WINGS NURSERY, LIDSEY, WEST SUSSEX

PROPOSED NEW ACCESS

Stage 1 Road Safety Audit

SR/LS/17/1545/RSA1

SMO	ALB	PMR
December 2017	2017/3711/001	C

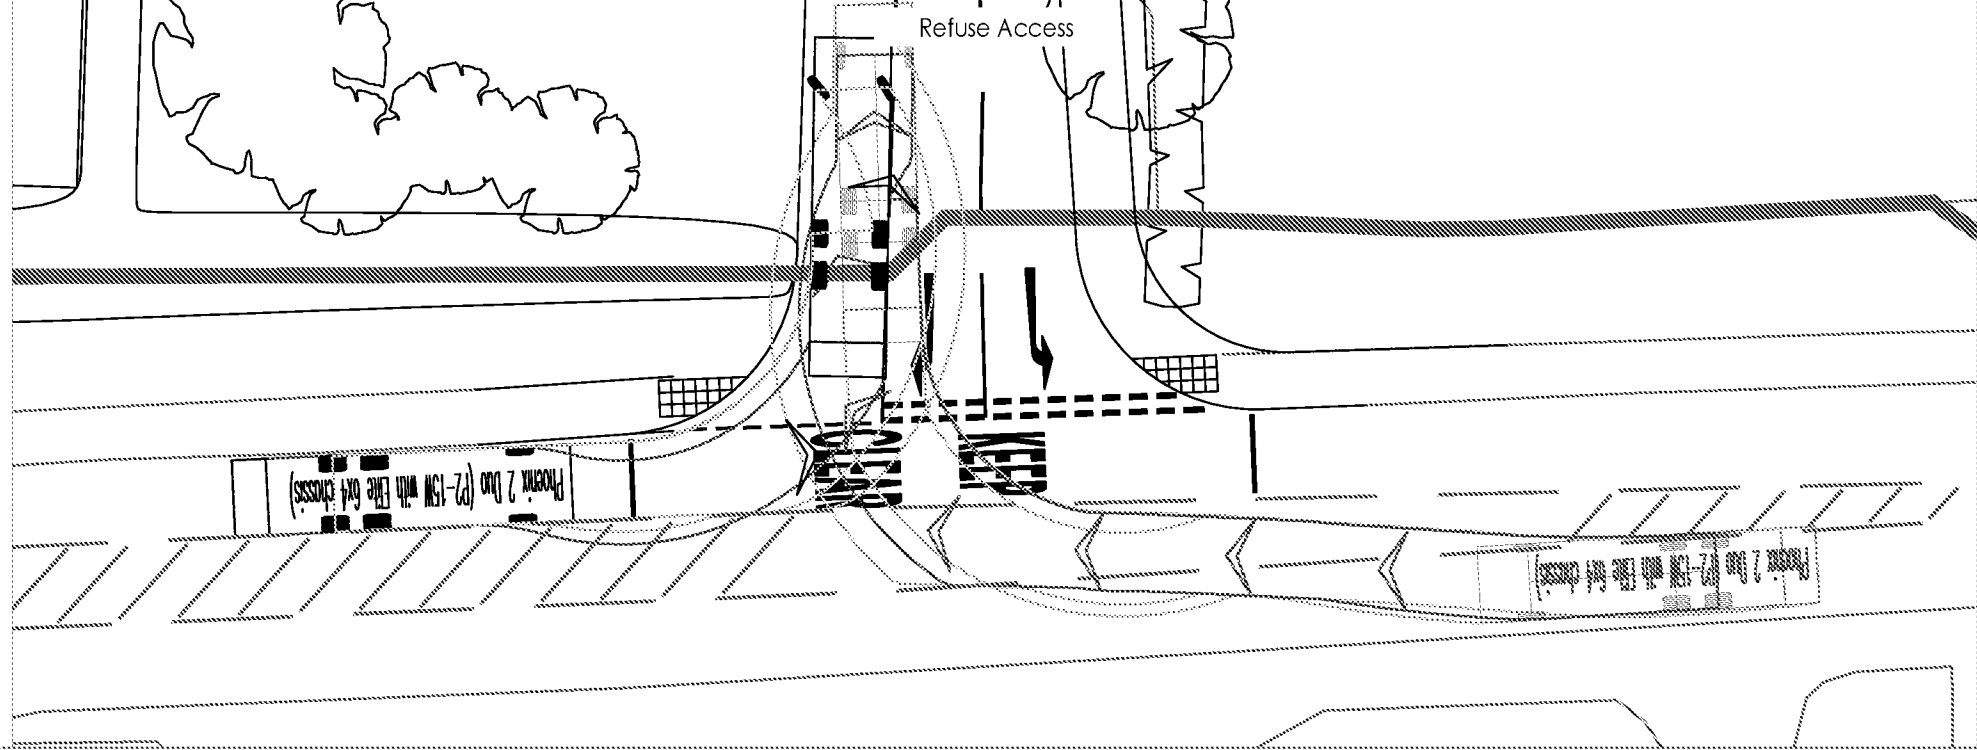
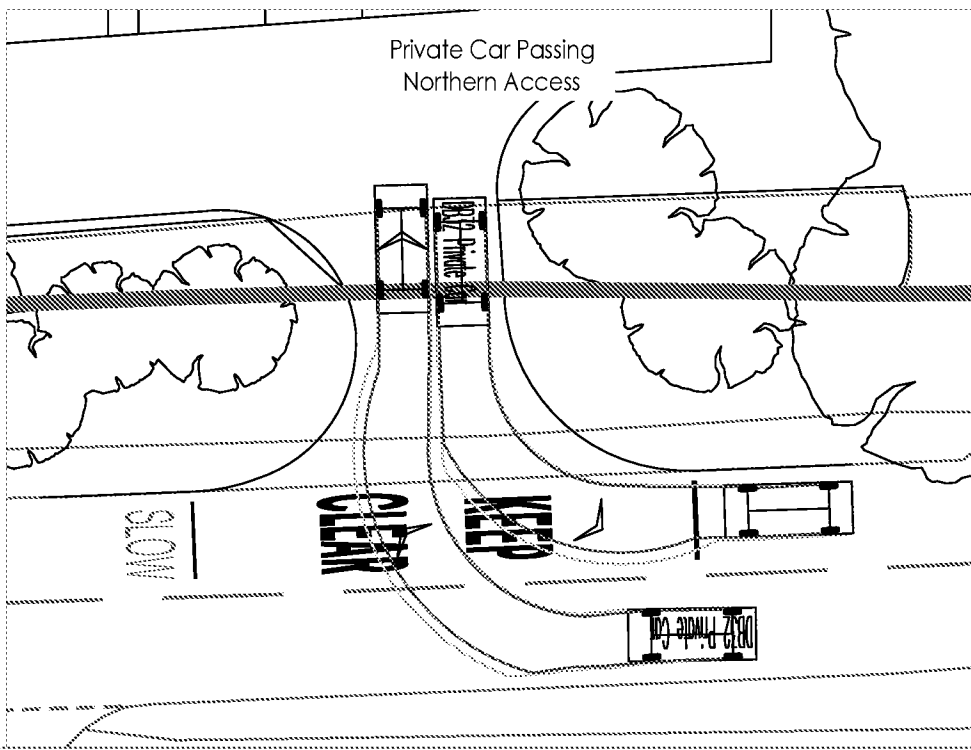
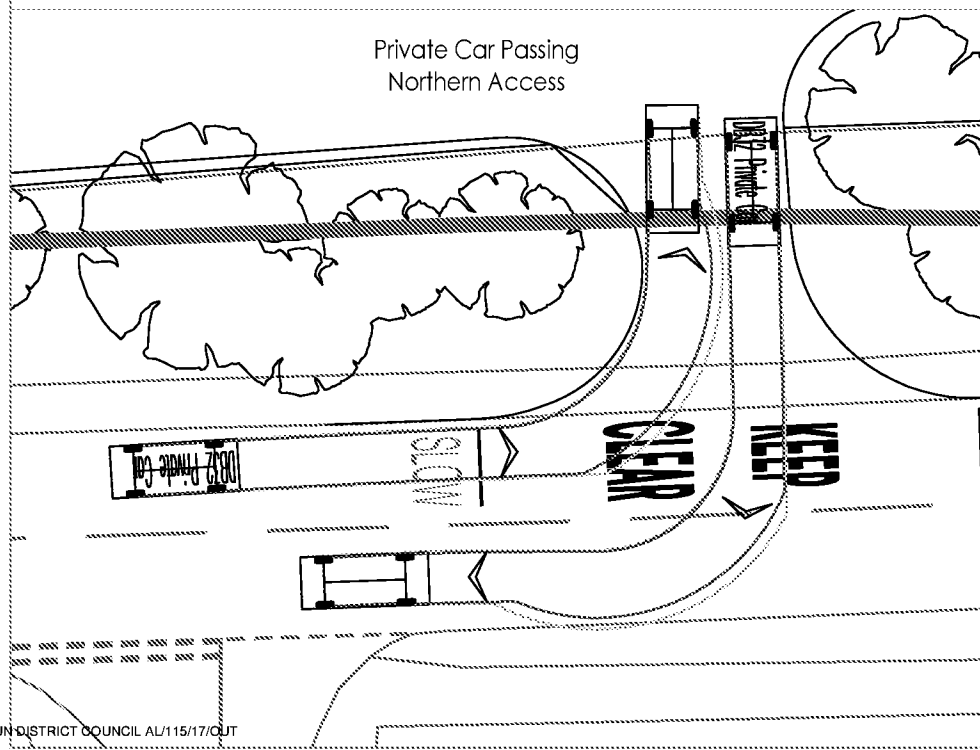
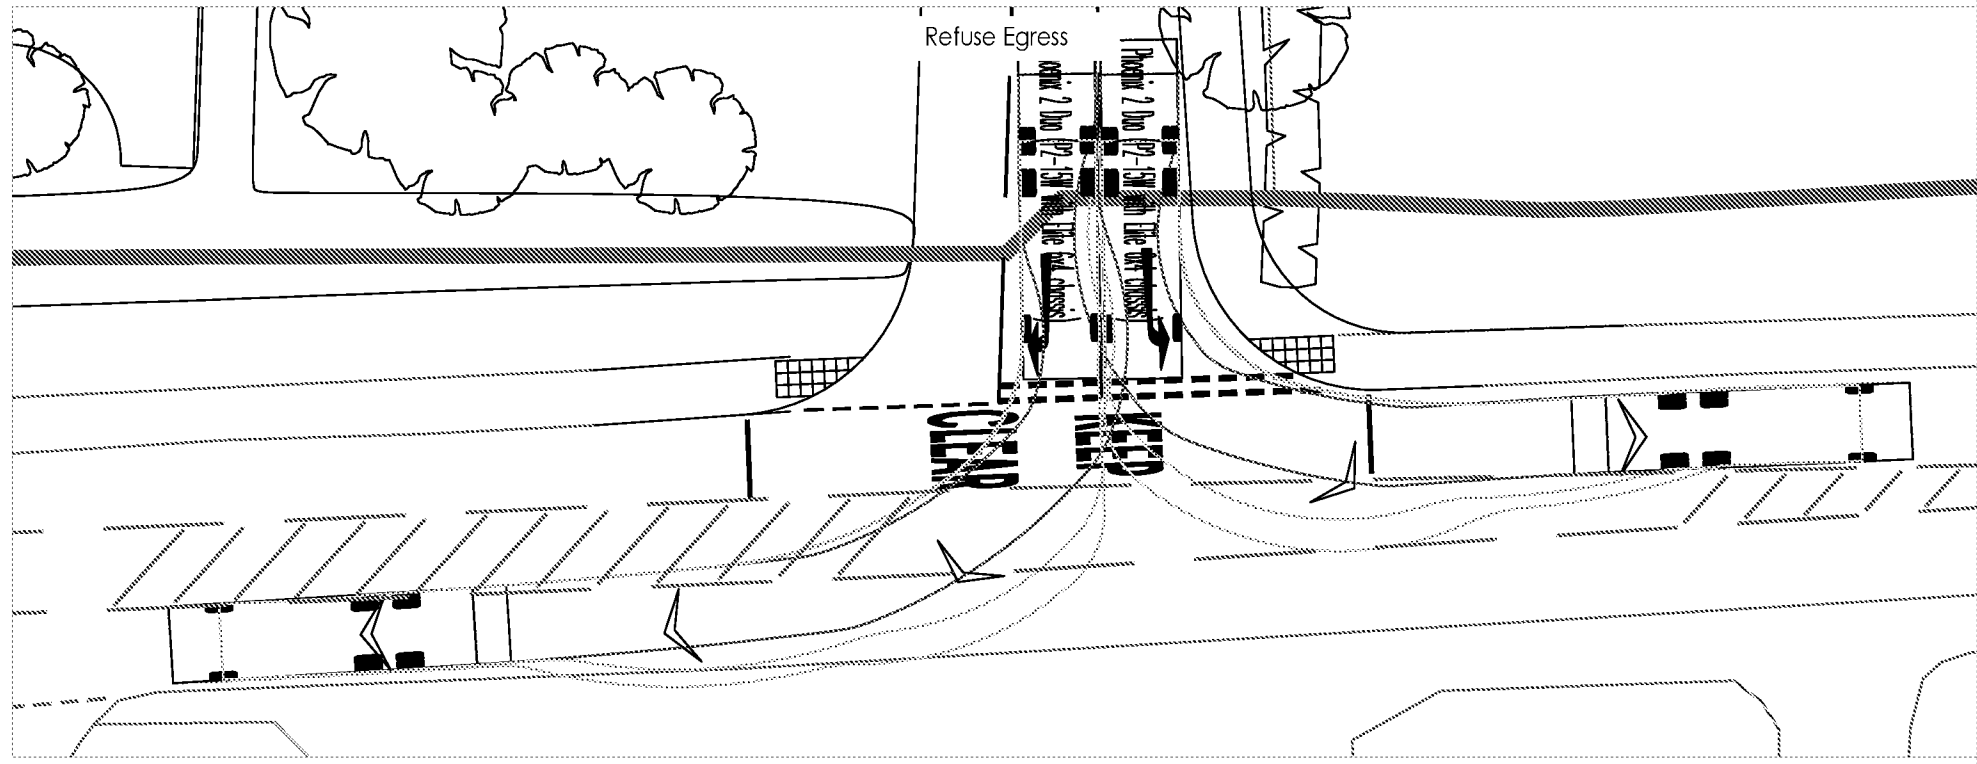
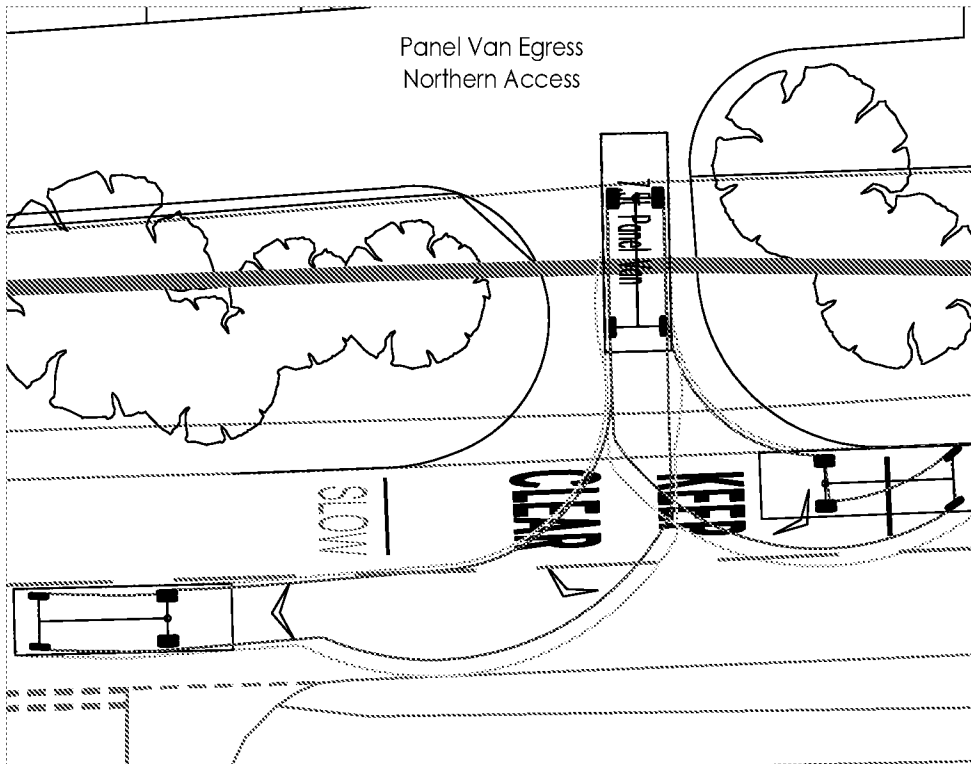
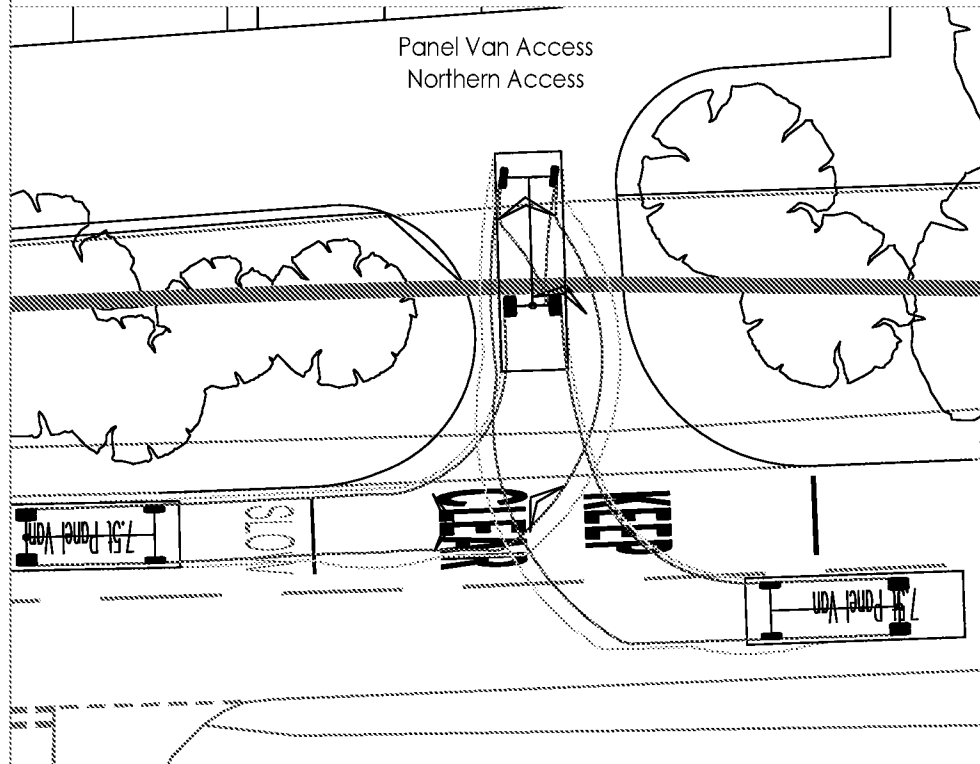
The Audit Team noted the tactile paving shown on the drawings do not conform to the tactile paving standards for an inline crossing point. There is a risk that this would confuse blind and partially sighted pedestrians.

Ensure that the correct tactile paving layout is installed.

The Audit Team noted that the trees to the north of the access were obscuring the visibility of vehicles exiting the development. There is a risk that sight lines would be hindered which may result in collisions.

Ensure that all vegetation is cut back and regularly maintained.
